# CITY OF ALBUQUERQUE

**Re: 201 Princeton SE  
201 Princeton SE  
Request for Permanent C.O. - Accepted  
Engineer's Stamp dated: 4-17-15 (K16D082)  
Certification dated: 4-5-15**

RE: **201 Princeton SE**  
**Grading and Drainage Plan**  
**Engineer's Stamp Date 4-17-2015 (File: K16-D082)**

**RE: Lot 24, Block 18, University Heights, 201 Princeton Drive SE  
Grading and Drainage Plan  
Engineer's Stamp Date 3-24-2015 (File: K16-D082)**

## GRADING AND DRAINAGE PLAN

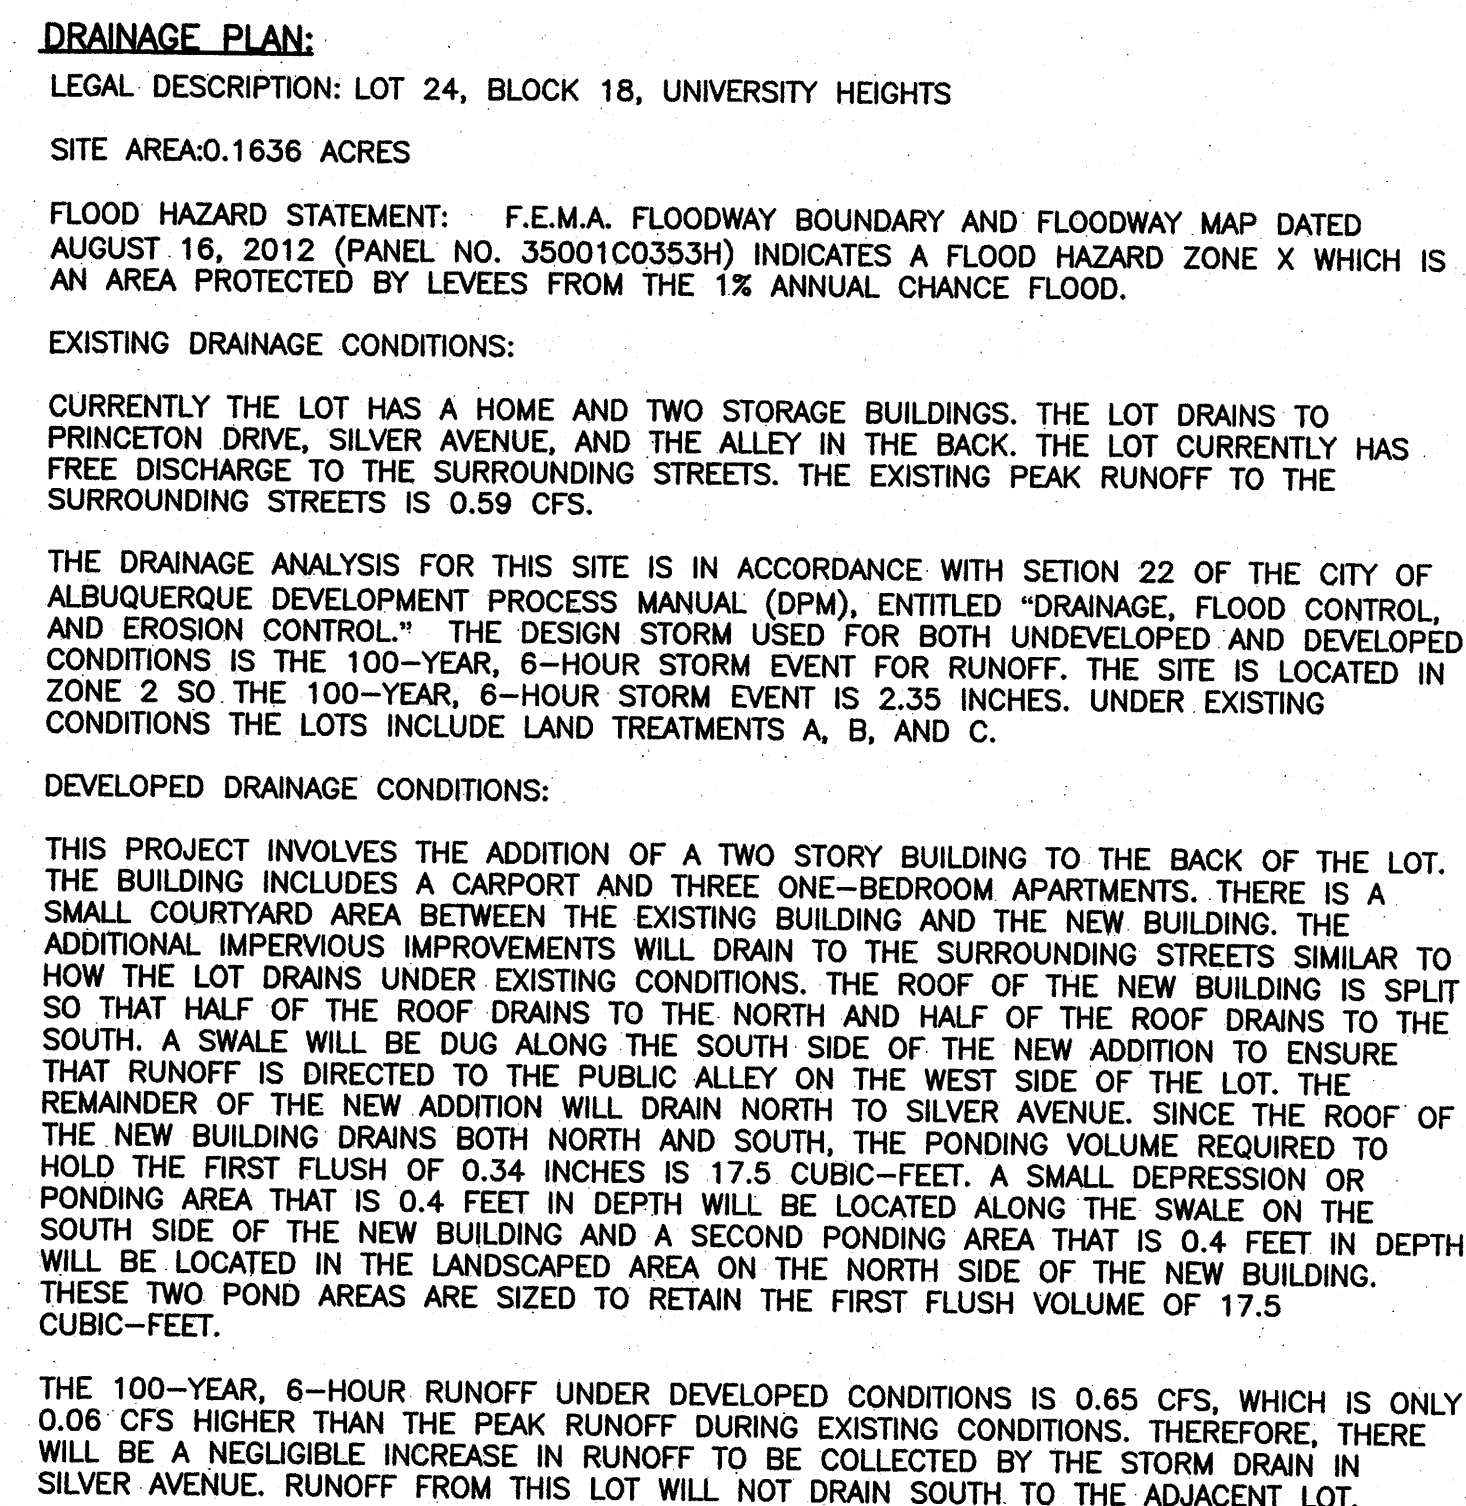
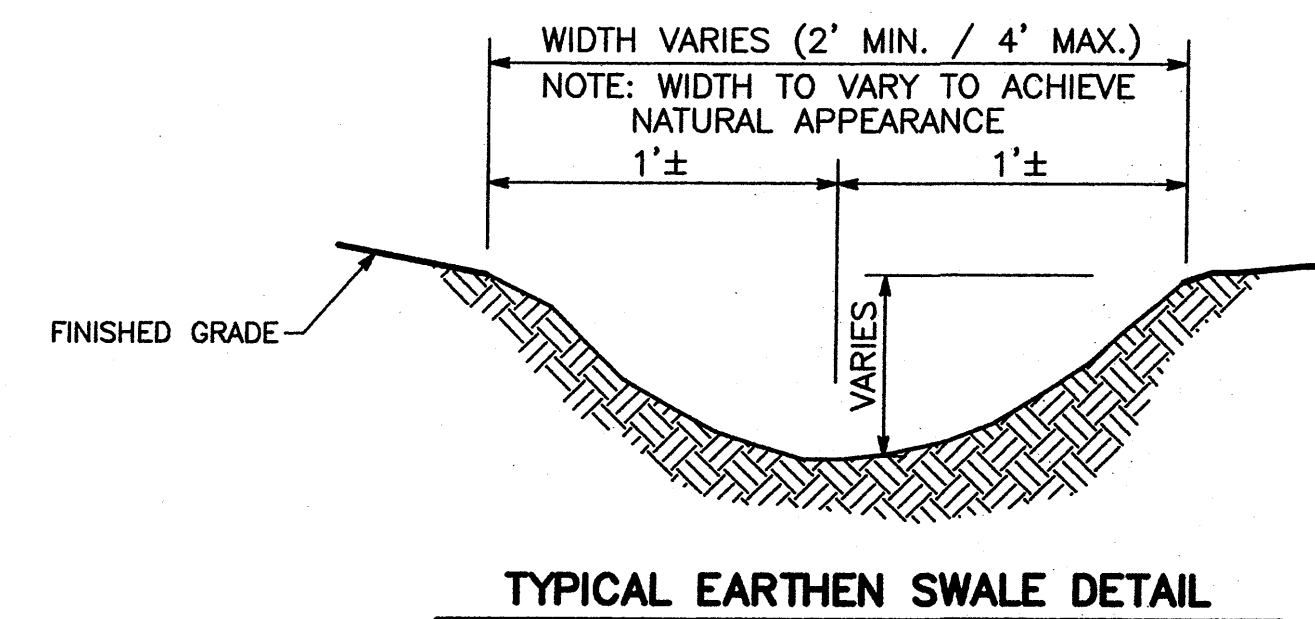
- 1) Label the area of the new building addition on the plan view, and label the existing building. Show property lines and actual basin boundary line on the plan view. Label the public alleyway.

- 2) As a result of the added impervious area, address first flush management as required per the COA Drainage Ordinance which is defined as 0.34" times the impervious area. Also, show all roof drains for the new building. It looks like there is opportunity to retain first flush volumes either immediately north of the new building or south of the building within the proposed swale. Show first flush computations.

- 3) For the 100-year hydrologic calculations, label "Existing Total Runoff" and "Proposed Total Runoff". Also, within the legend, show legend for new concrete, existing building, new building, and existing spot elevations.

- 4) In the discussion for Developed Drainage Conditions, address the site's ultimate discharge into the storm drain in Silver Avenue.
- 5) Provide a detail for the swale along the south side of the new building and its connection to the public alleyway and/or Princeton Drive, and provide more spot elevations for this swale. Show all existing curb as applicable in these areas. In the discussion for developed drainage conditions, address any impact of on-site drainage to the property south of the new development. If some of the on-site drainage is discharged to Princeton Drive, address this in the write-up.

- 6) Provide width of public alleyway on the plan. Include more detail for the proposed driveway, including calling out a width and applicable COA standard drawing details. Showing a top of curb elevation for the new driveway seems to conflict with the driveway location unless this top of curb also represents the flowline. Label the location where new curb ties to existing curb.
